STATE OF NORTH CAROLINA
DEPARTMENT OF TRANSPORTATION

SUBJECT: Wilson County, SR 1158 (Airport Blvd) from North of NC
42 to US 264; T.I.P. Number U-3823; Federal Aid Project
STP-1158(2); State Project 8.2341801

**DEPARTMENT OF THE ARMY
WILMINGTON DISTRICT, CORPS OF ENGINEERS**

Subject: Modification to the 401 Water Quality Certification Pursuant to Section 401 of the Federal Clean Water Act and NEUSE BUFFER RULES, with ADDITIONAL CONDITIONS for Proposed widening to SR 1158 in Wilson County, Federal Aid Project No. STP-1158(2), State Project No. 8.2341801, TIP No. U-3823. DWQ Project No. 20051764 ver.2.

N.C. DEPT. OF TRANSPORTATION  
 DIVISION OF HIGHWAYS  
 WILSON COUNTY  
 U-3823  
 SR 1158 (AIRPORT BLVD.) FROM  
 EAST OF NC 42 TO EAST  
 OF US 264-A  
 DATE: MAY 2007  
 SHEET 11 OF 15

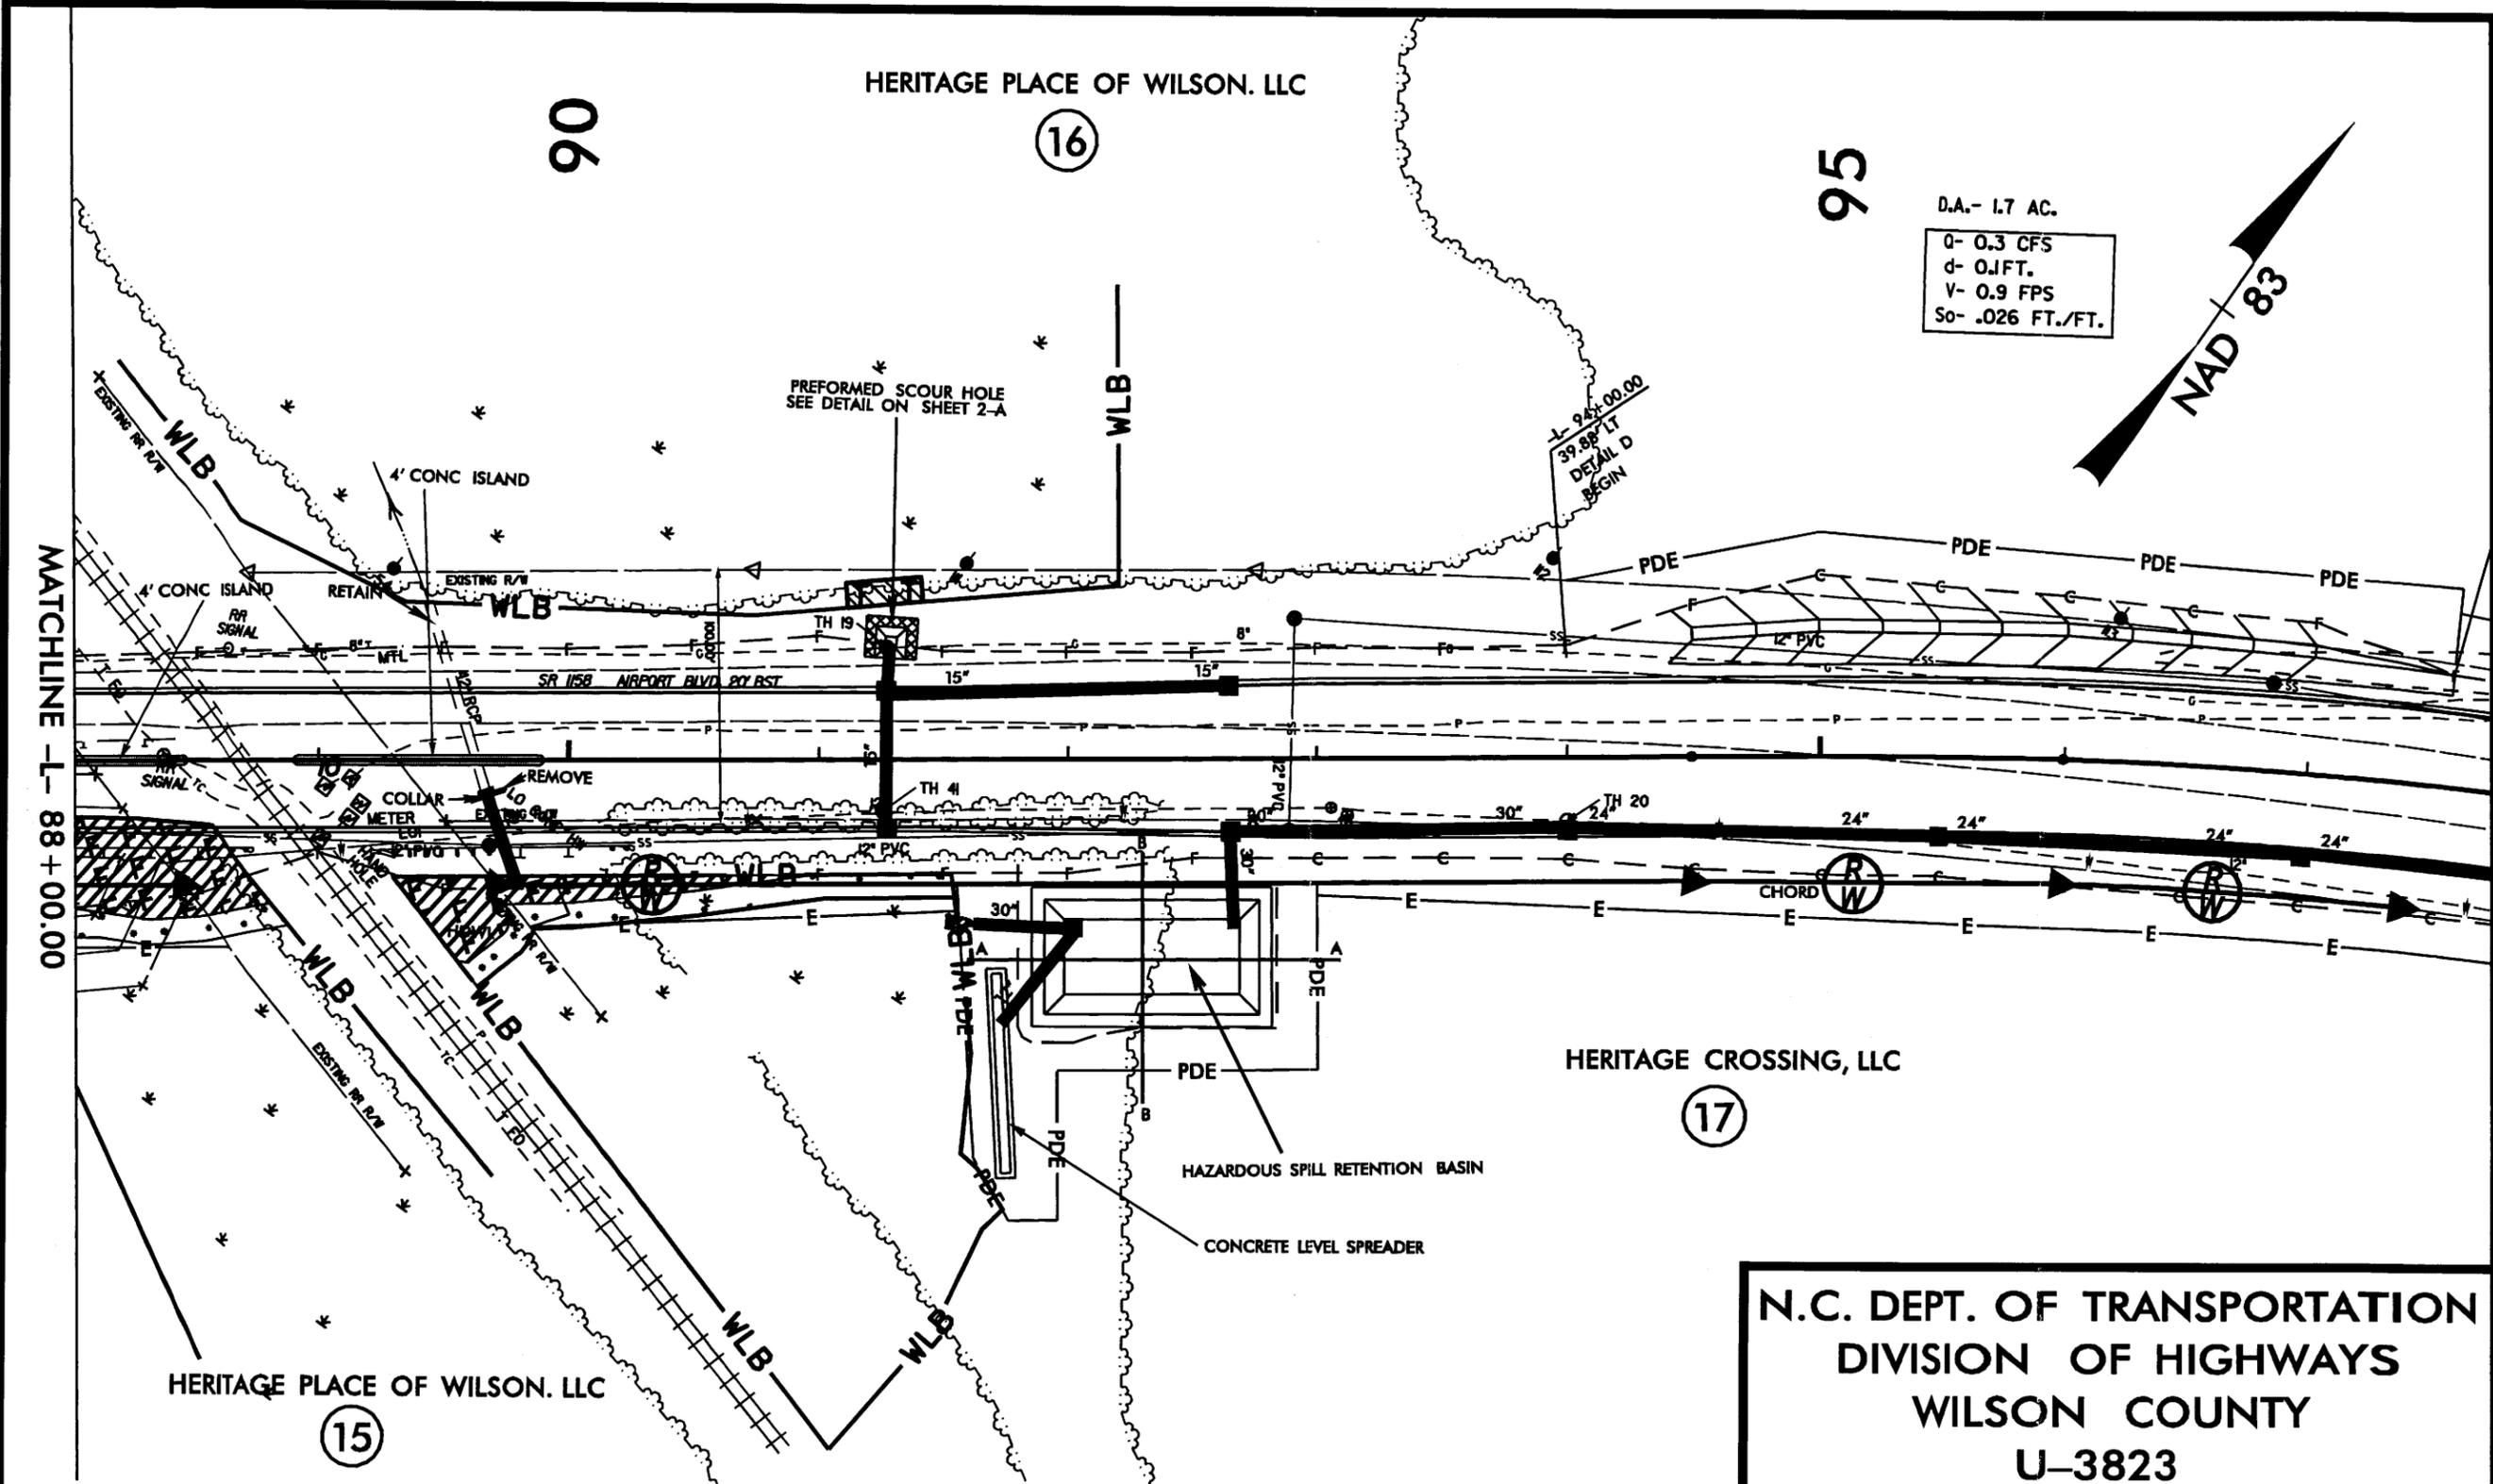
1. Section A, Site 1: Clarify wording to read "temporary fill in wetlands"
2. Section A, Site 2:
 - 0.585 acres of permanent fill in wetlands
 - 0.032 acres of excavation in wetlands
 - 0.268 acres of mechanized clearing in wetlands
 - 0.132 acres of temporary fill in wetlands
 - 0.175 acres of temporary fill in surface waters (workpad)

The permit is hereby modified to include the work as indicated above and shown on the enclosed plans. It is understood that all conditions of the original permit remain applicable and that the expiration date is unchanged. It is also understood that the 12-foot by 9-foot pentuple barrel culvert in Section A, Site 2, will be removed in its entirety.
